8 November 2013

**Re: Materials Recycling Facility – Moorebank (05\_0157)  
Exhibition of Preferred Project Report**

**Tanya O'Brien**  
Manager Strategic Planning

FIGURE 7
ESTIMATED PEAK HOUR (PCU'S) VOLUMES AT
BRICKMAKERS DRIVE/LINK ROAD INTERSECTION

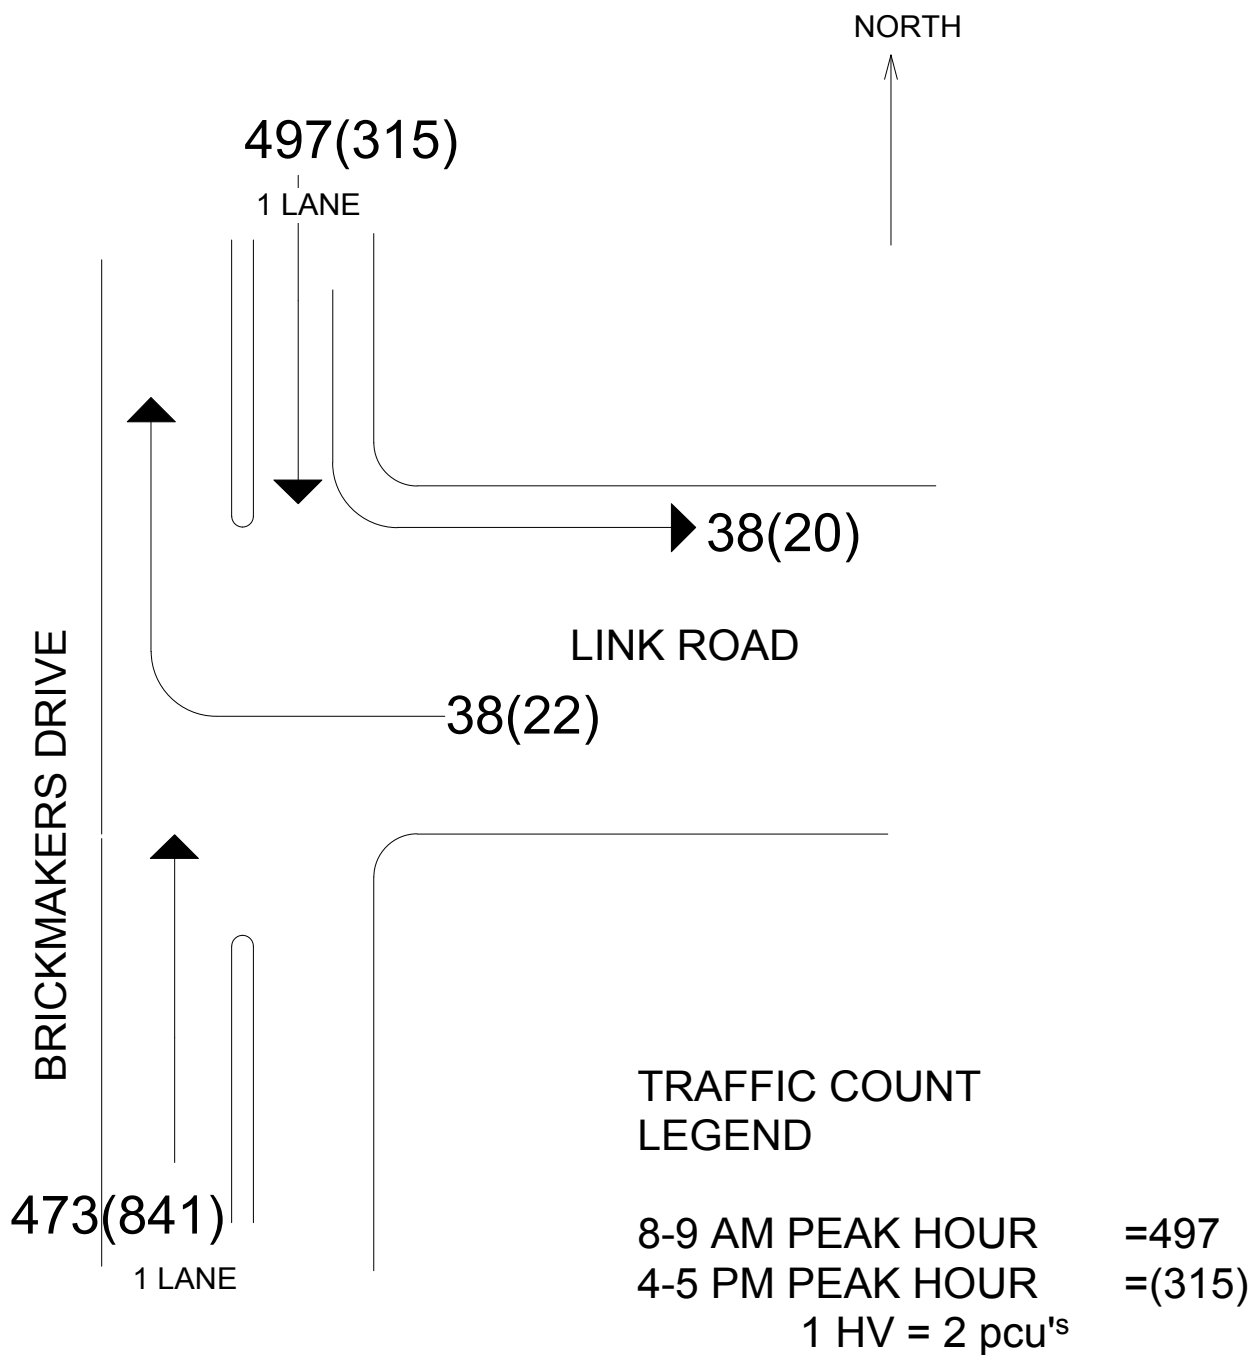
- The intersection treatment of the proposed access and Brickmakers Drive;
- The cumulative traffic impact of other proposed developments that would use the link off Brickmakers Drive;
- The directional distribution of heavy vehicle traffic from the site;
- The impact on road pavement; and
- The impact of traffic noise on residential receivers and recreation areas.

LONGITUDINAL SECTIONS

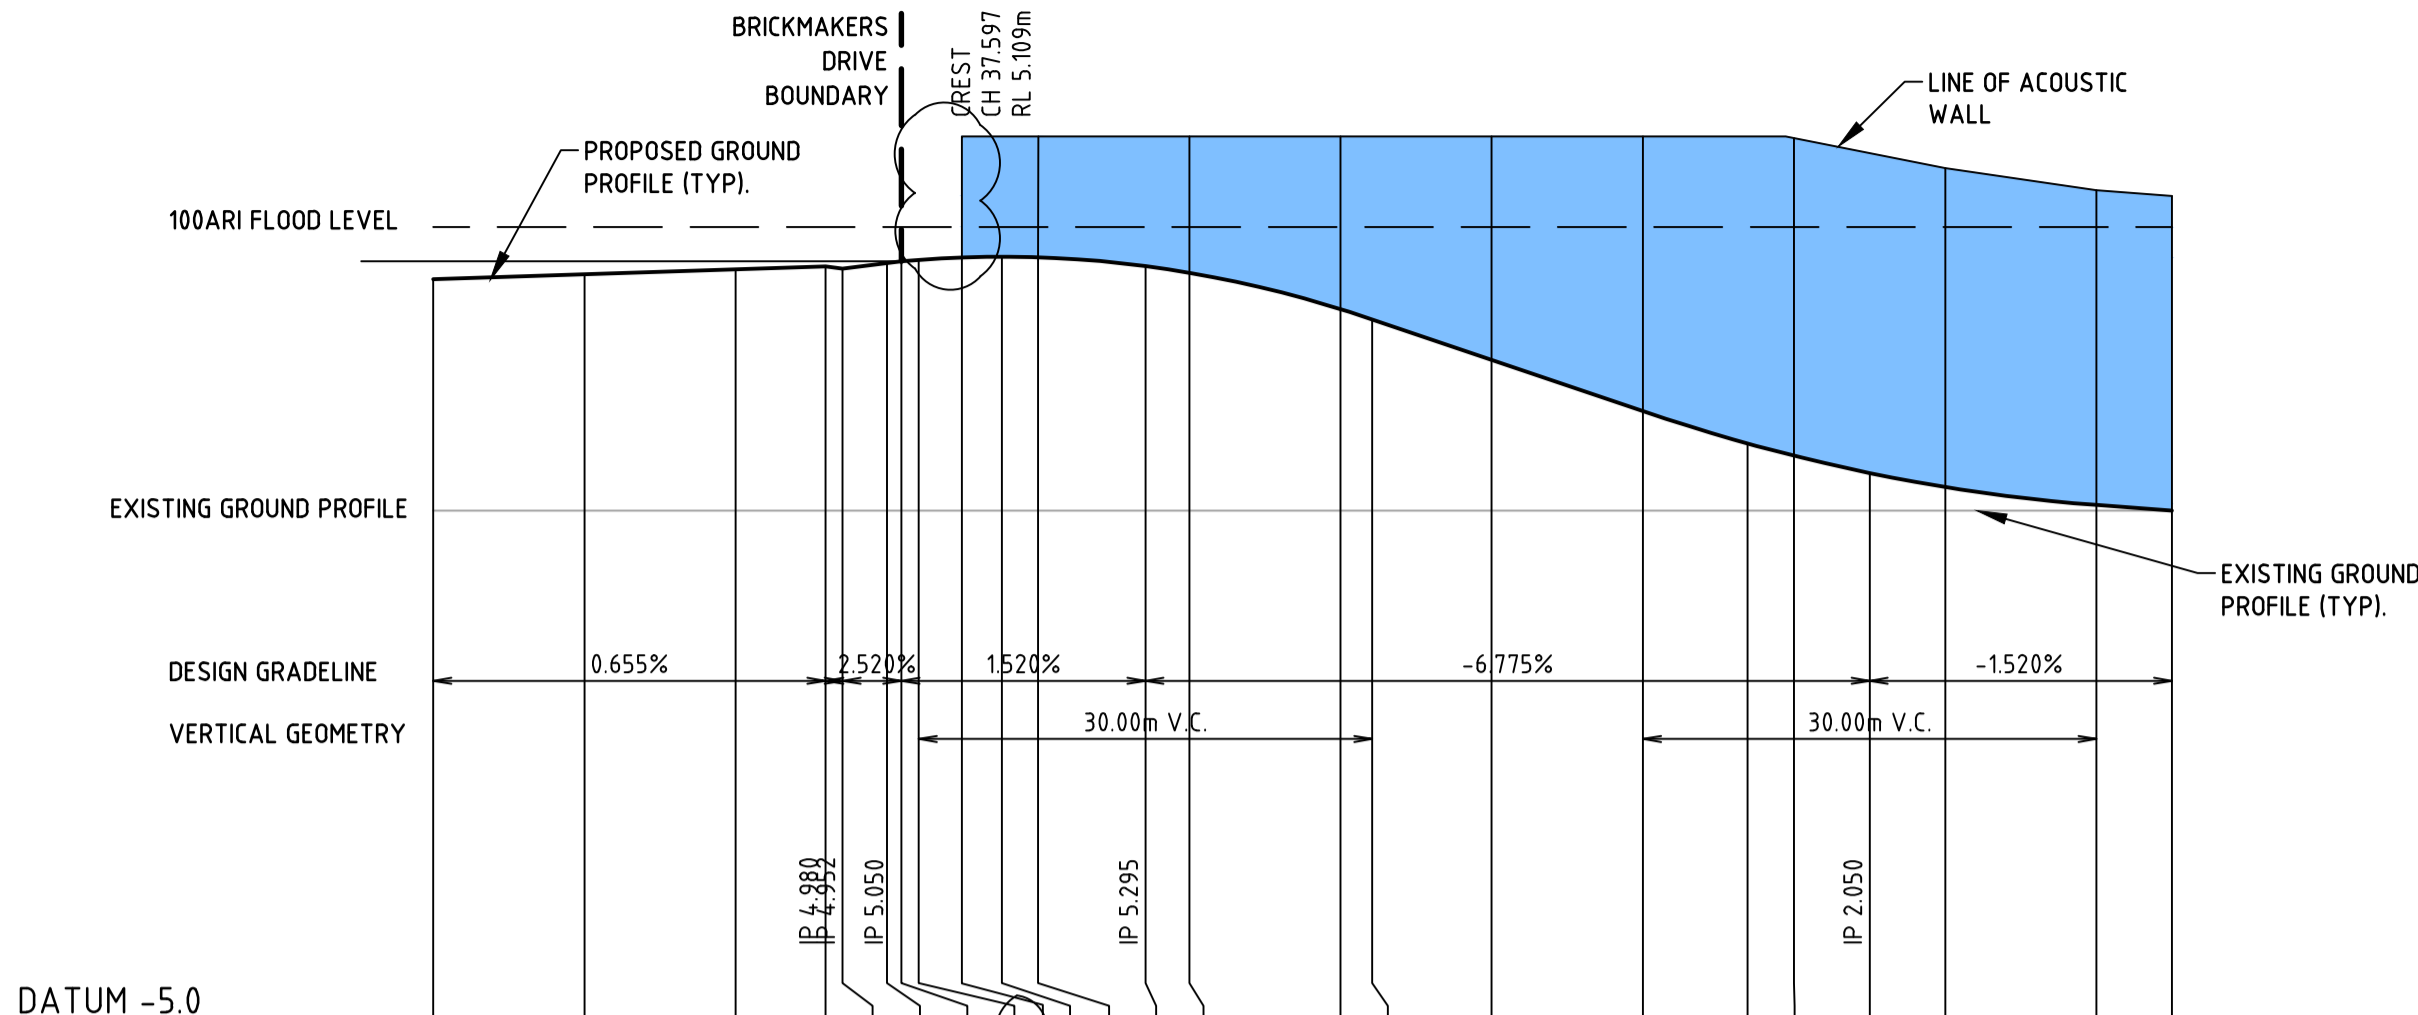
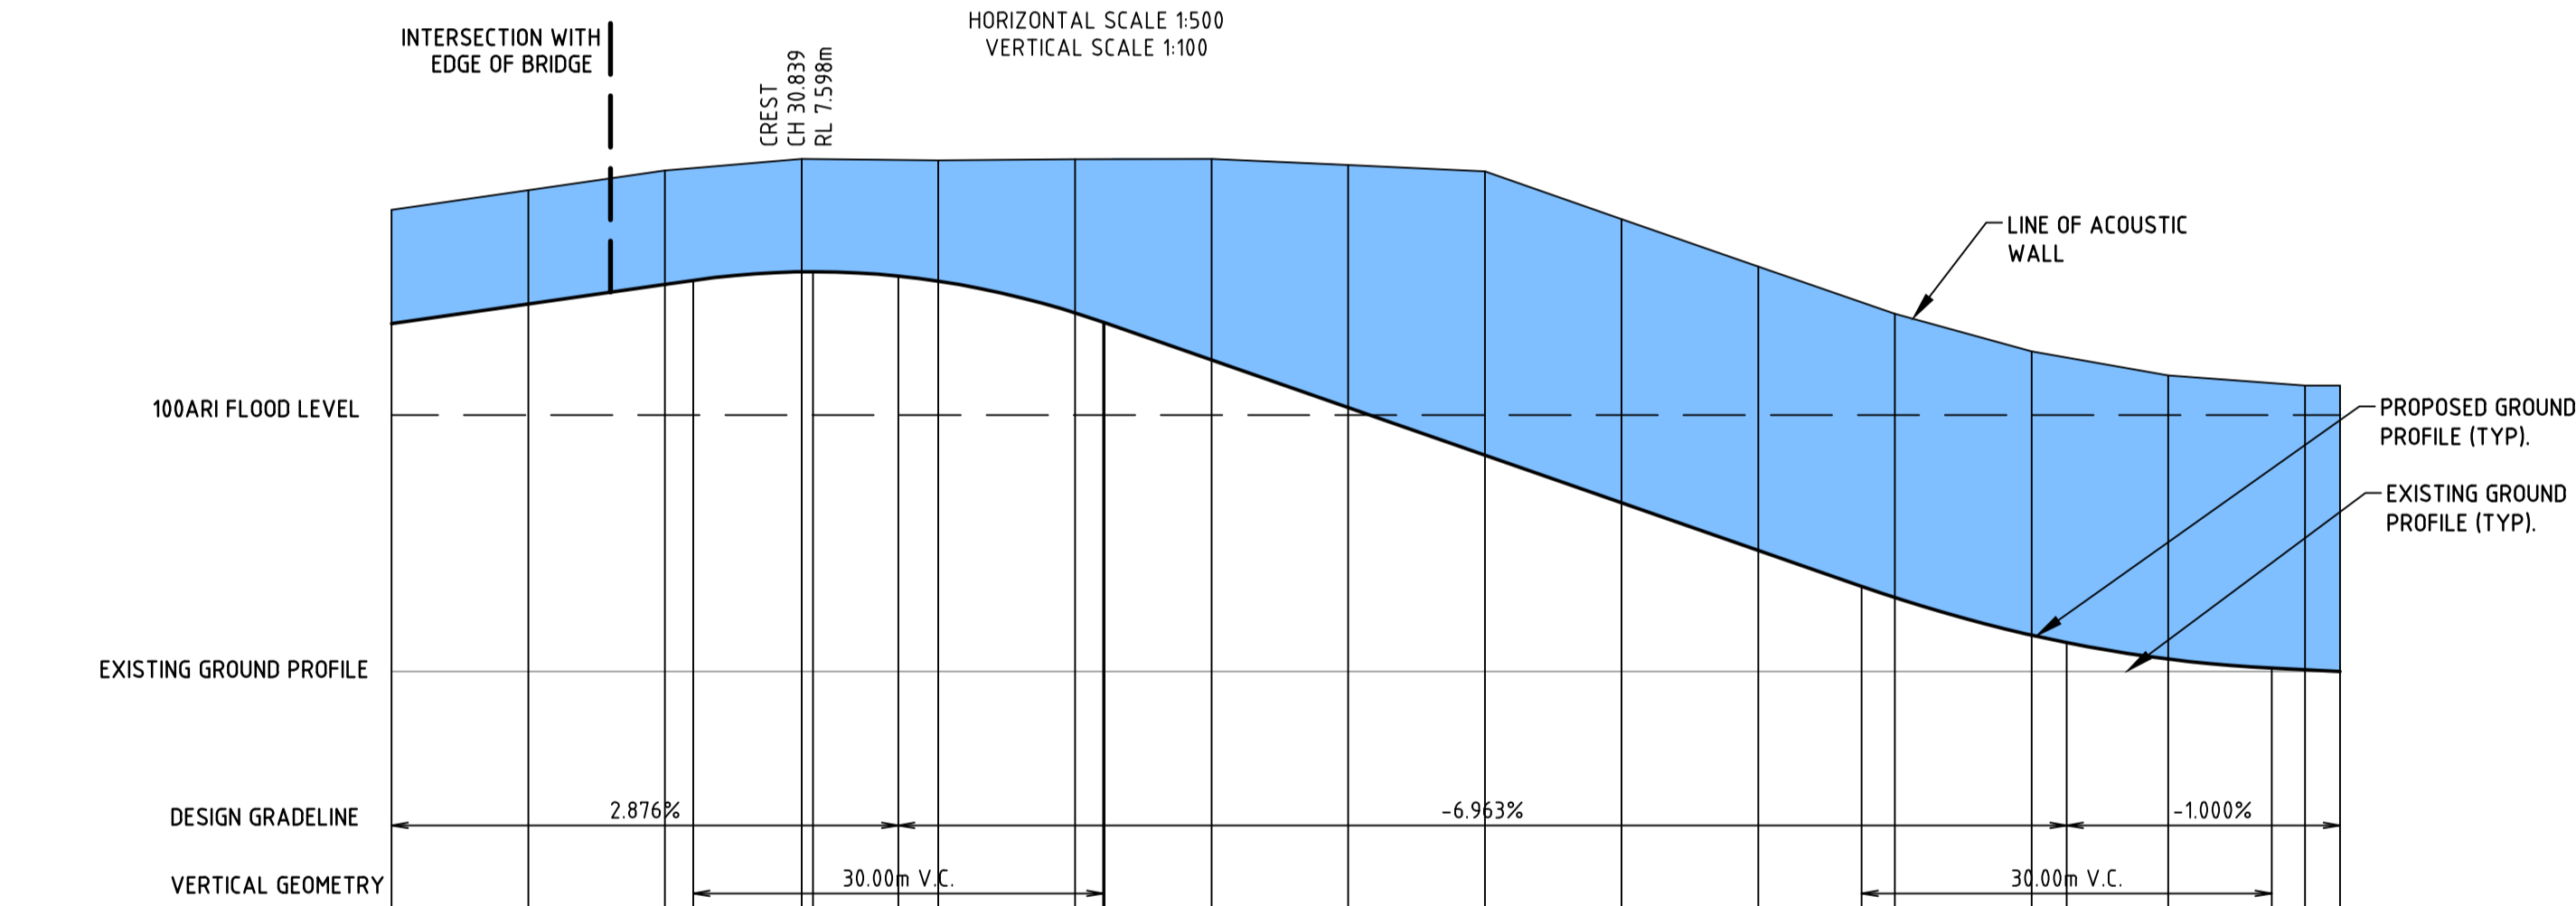
- The flood impacts arising from the ramps attached to the bridge have not been properly assessed through flood studies undertaken by appropriately qualified flooding engineers in accordance with Council's flood model. This is not acceptable.

Furthermore, the increase in height of the bunds will have a significant impact on the flood behaviour. Council is not satisfied with the information provided by the proponent with regard to flooding.
